CITY OF ALBUQUERQUE

May 8, 2018

RE: **North Second St Storage**
5124 2nd St NW
Grading Plan Stamp Date: 5/1/18
Drainage Report Stamp Date: 5/2/18
Drainage File: F15D052E

Based on the information provided in your submittal received 5/3/18, the grading plan and drainage report cannot be approved until the following are addressed:

EXISTING BASIN BOUNDARIES

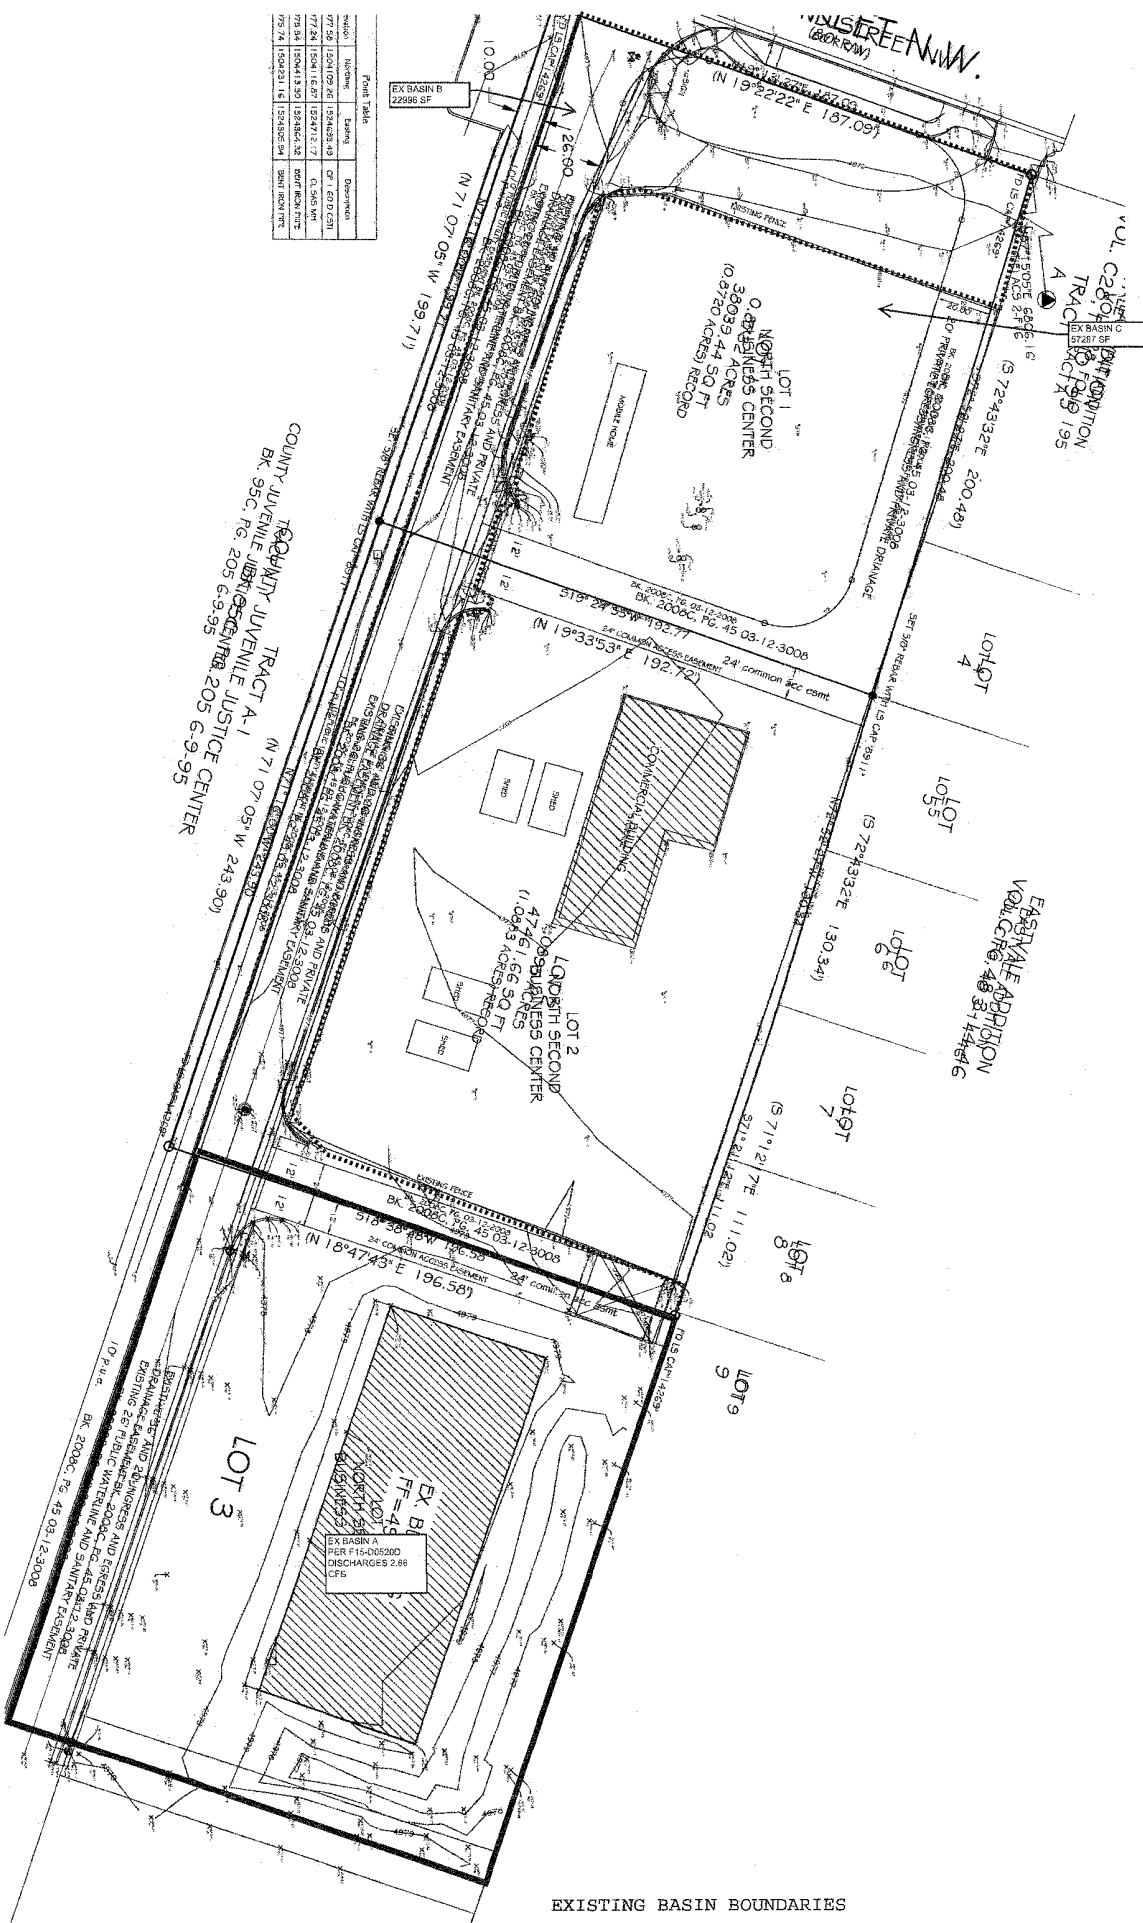
1. Please correct and clarify the site hydrology.
 - a. The basins in the basin delineation map need to be labeled, some labels are duplicated or missing and these need to match what's shown on the excel spreadsheet.

- b. The portion of lot 3 that currently drains to its ponding area needs to be considered as retention and cannot be considered when establishing the allowable/existing discharge rate for the larger project.

- c. The excel spreadsheet has additional basins that are not defined on the basin delineation maps, the 'proposed' and 'comparison' rows do not seem to be added correctly.

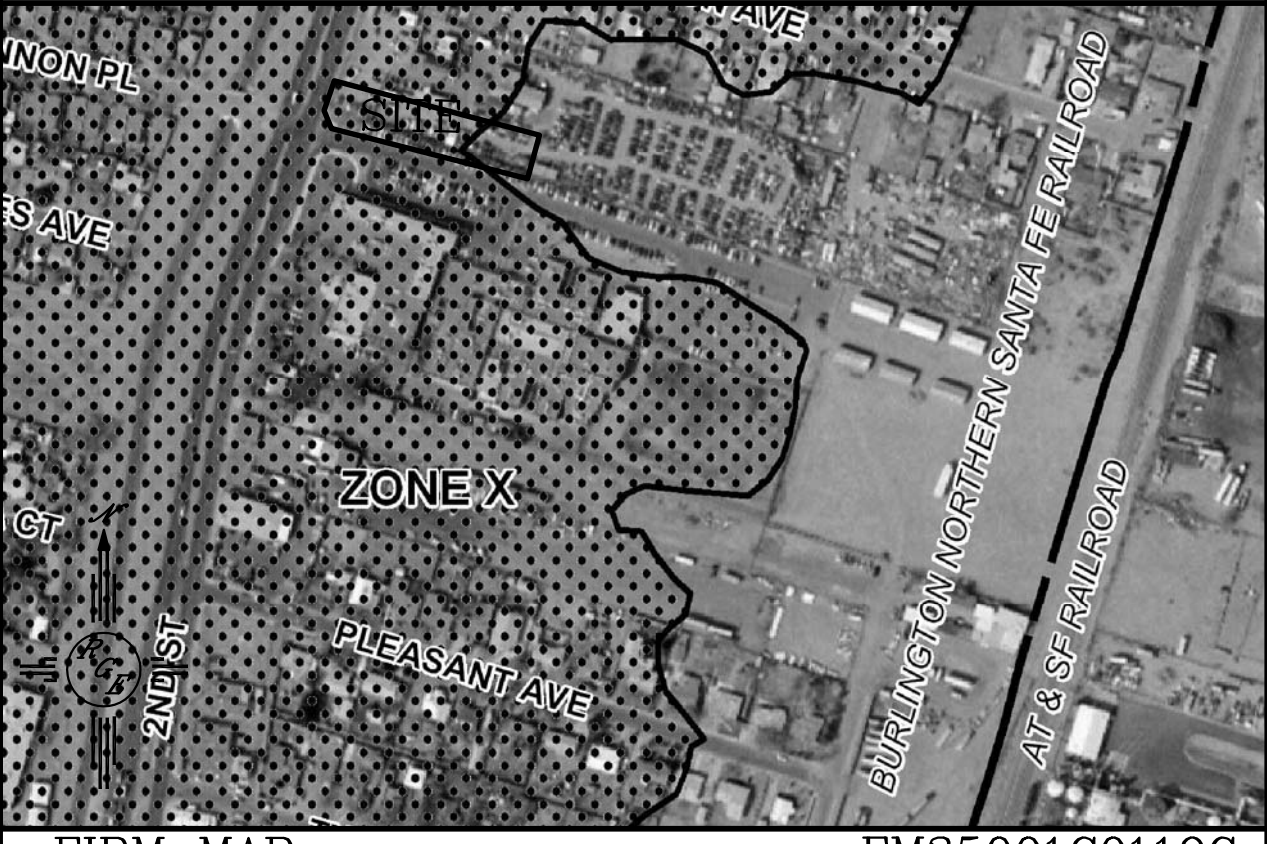
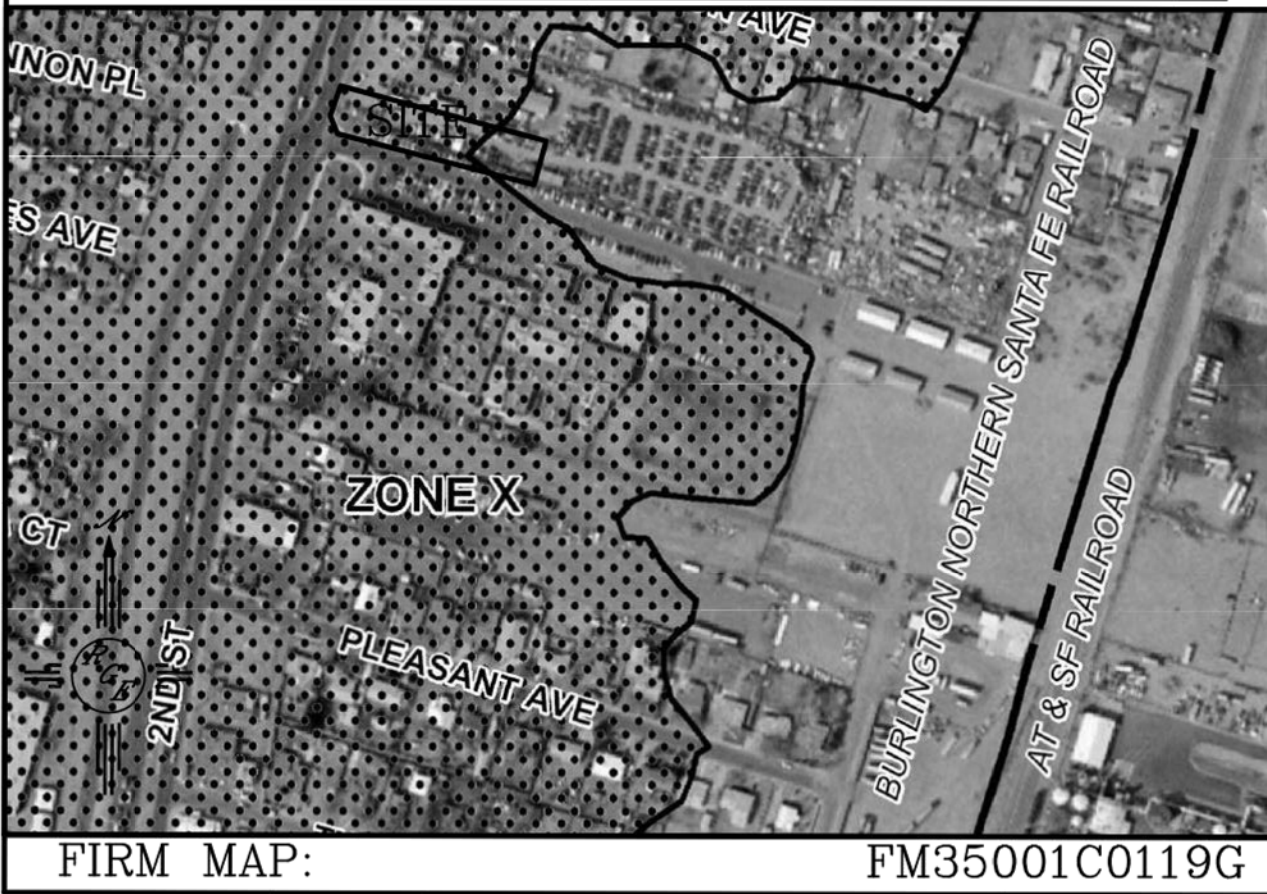
2. This project requires an ESC Plan, submitted to the Stormwater Quality Engineer (Curtis Cherne PE, ccherne@cabq.gov or 924-3420).
3. Show on plans where the emergency spillway from the storage units is; provide a section of this with elevations and dimensional data. Provide hydraulic calculations to demonstrate that it can pass the 100-yr peak flow without flooding the storage units.
